2024/0625

Address: 3 Hallcroft Gardens, Great Houghton, Barnsley, S72 0BH

Description: 2 storey side extension to 2 storey semi-detached dwelling

SITE PLAN  
SCALE 1:500 AT A3

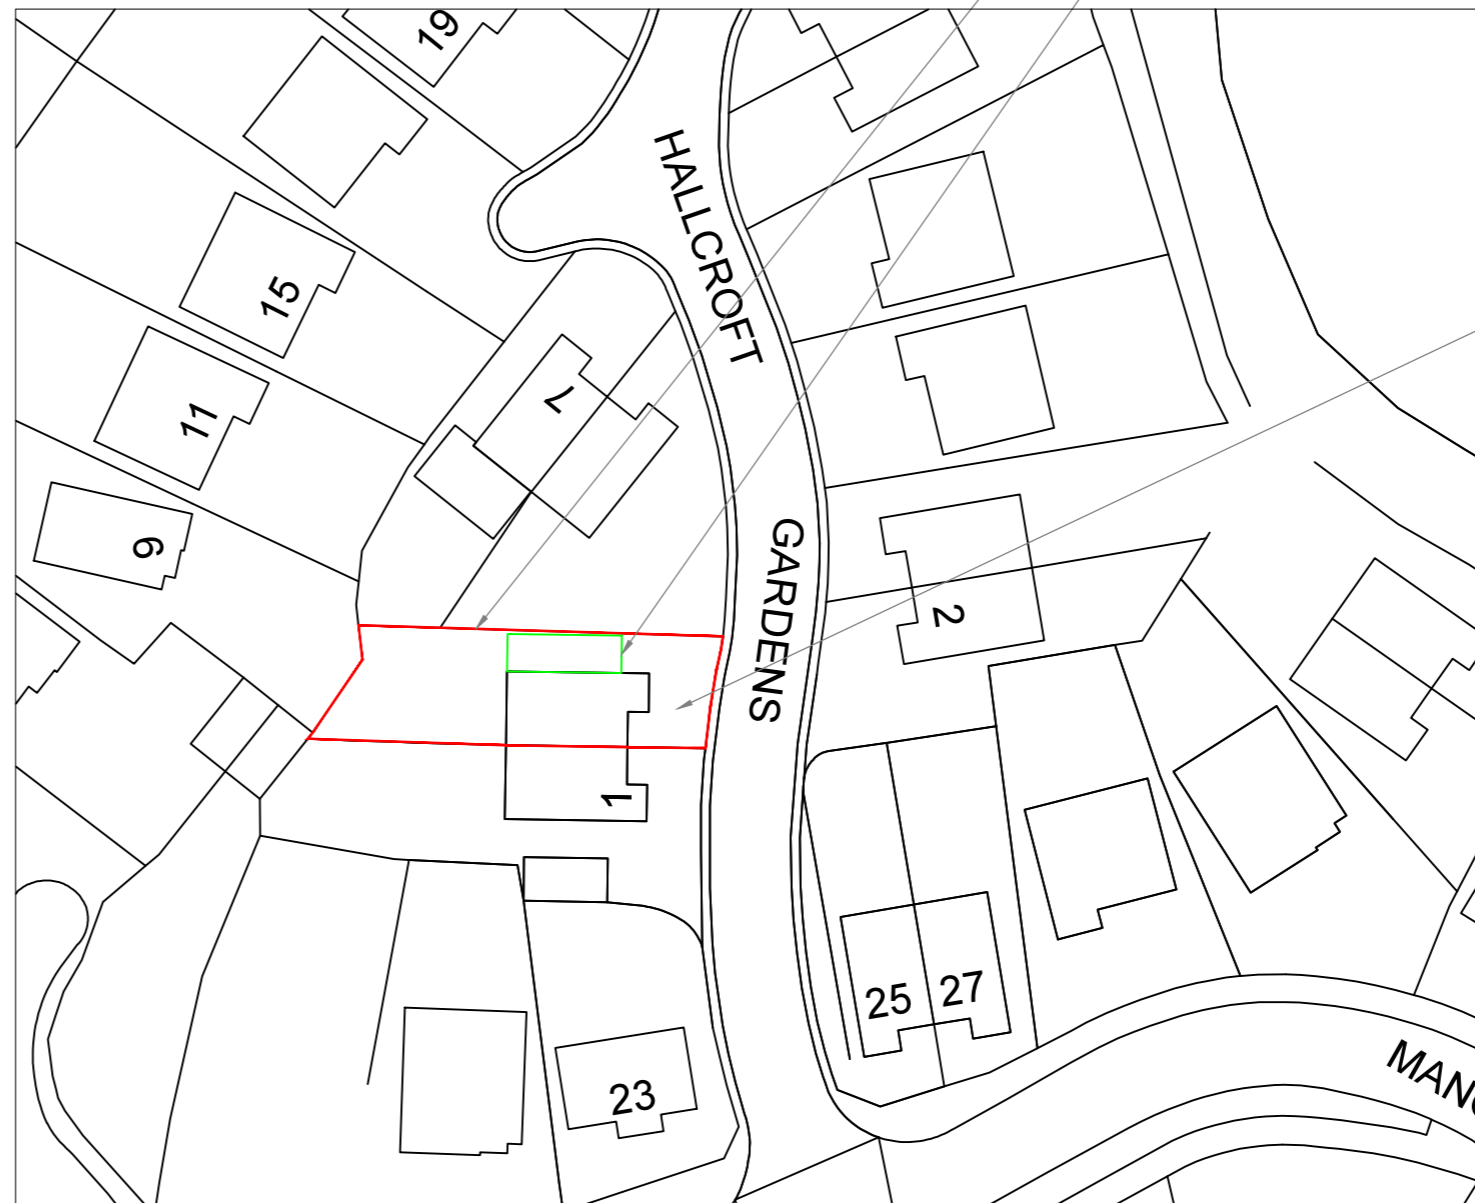
Highways DC: Following initial concern over an increased number of bedrooms and a lack of adequate parking provision. Amended plans were submitted indicated that an area of gravel to the front of the house would be hard surfaced, resulting in the objection from Highways DC being withdrawn.

Due to an increase in bedroom numbers from two to three, an additional hard standing parking space was requested by Highways DC and is proposed to be installed within the current graveled area at the front of the dwelling as part of the overall development. No other concerns about highway safety were raised.

PROPOSED FRONT ELEVATION
SCALE 1:100 AT A3

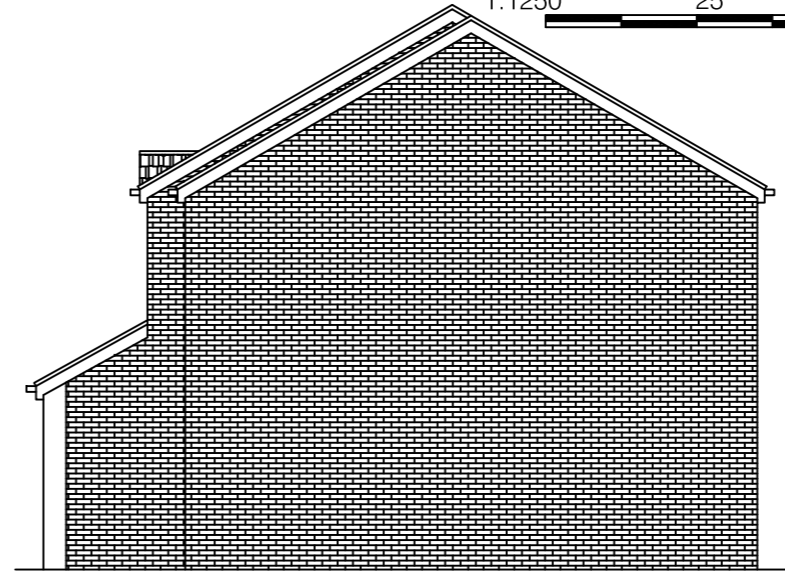
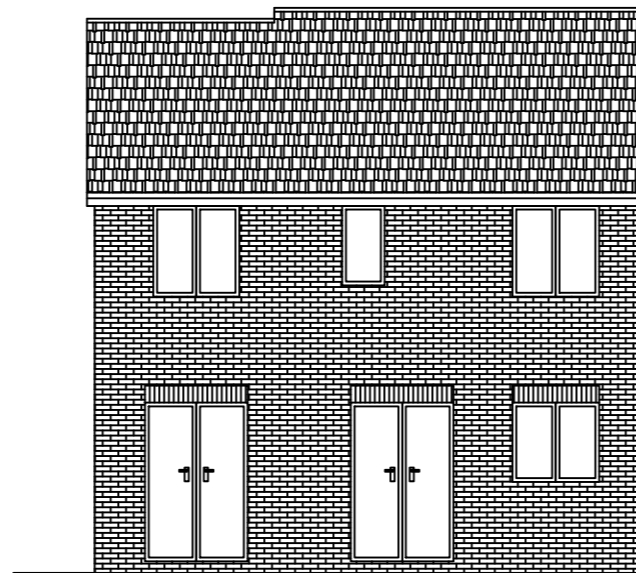
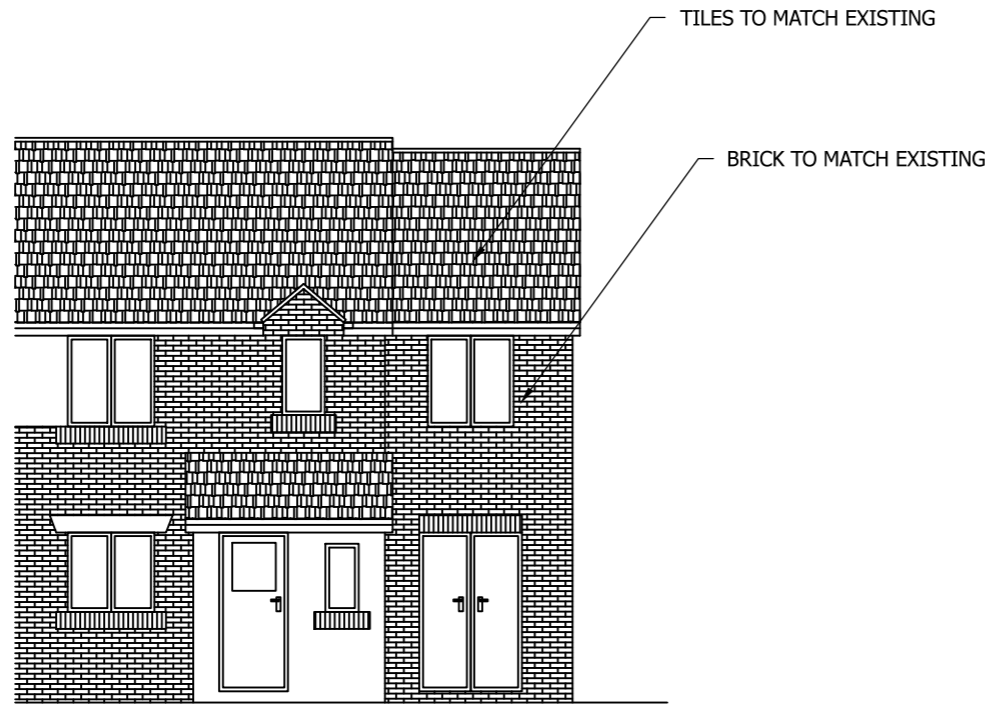
The proposal is two-storey, but the width of the proposal is quite modest, at approximately half of the width of the original dwelling (2.48m and 4.95m respectively). Although the front porch is already set forward from the main front elevation, the proposed extension is set back approx. 50cm from the front elevation and 1.88 from the front porch. An equal setback is included on the first story, which unlike the set down of the roof, match or exceed the recommendations within the SP. The set down of the roof would ideally have been larger but the approx. 15cm set down, combined with the ample set-back on both storeys does illustrate subordination to the original dwelling. Matching materials and roof style are proposed, which would help integrate the extension into the street scene.
